## **TOWN AND COUNTRY PLANNING ACT 1990 (AS AMENDED) Invalid Application**

**Application No.:** 19/02948/F

**Proposal:** Erection of 10 No two storey residential dwellings with access off South Side including a new pedestrian footway, parking and garaging, landscaping and all enabling and ancillary works

**Location:** Land To The South And Adj To, South Side, Steeple Aston

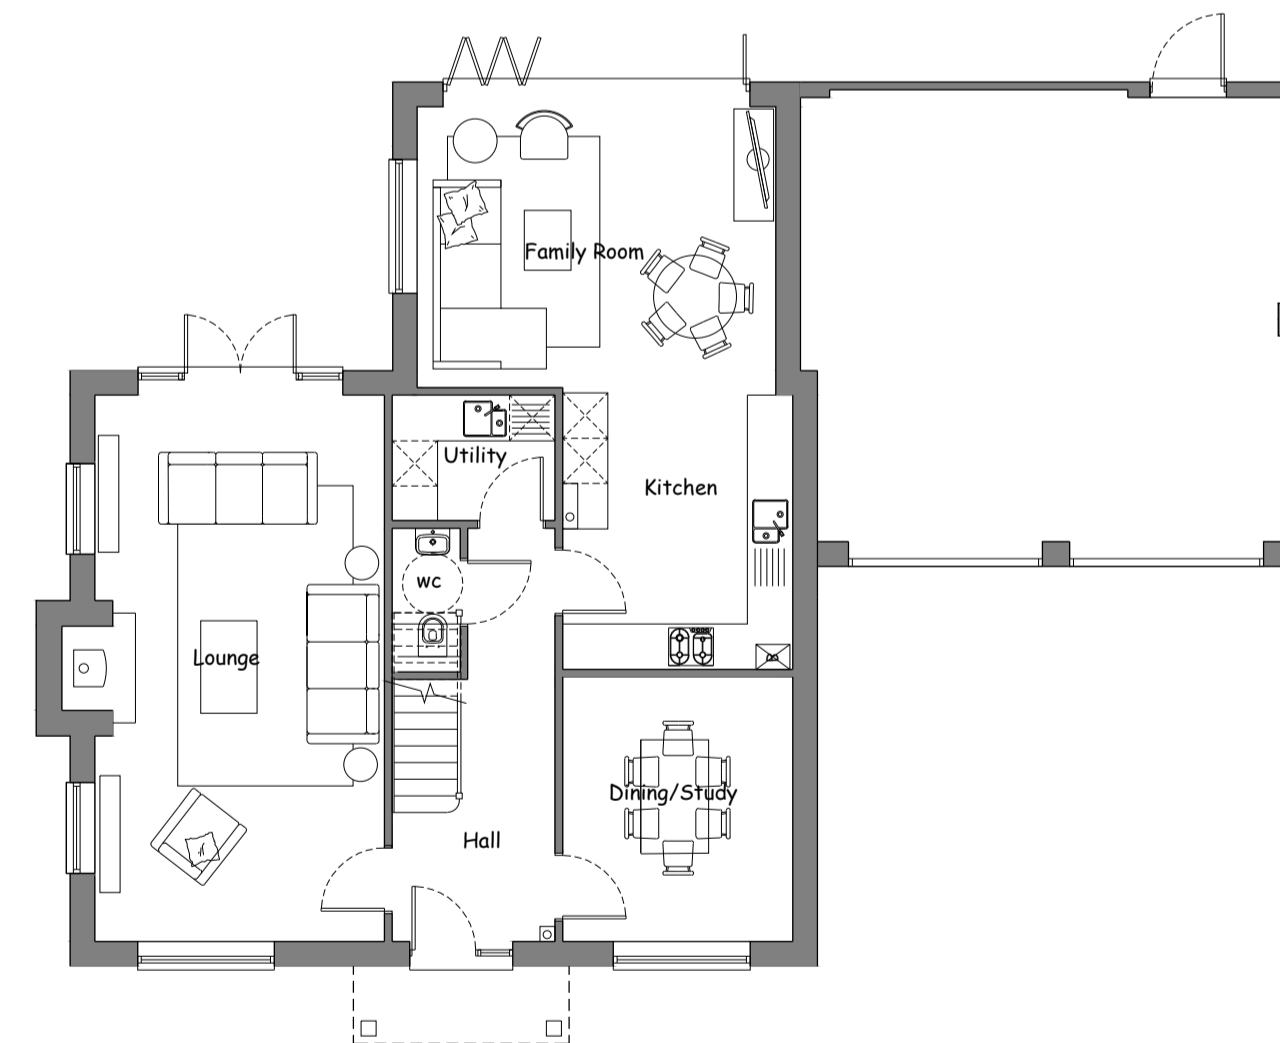
- Please re-submit Drawing number P.224.4B.DH.1795 (1220) - Plot 1 and 3 plans and elevations - as a small window to the upstairs en-suite has been indicated on the floor plans to the rear first floor but this window is not indicated on the rear first floor elevation.
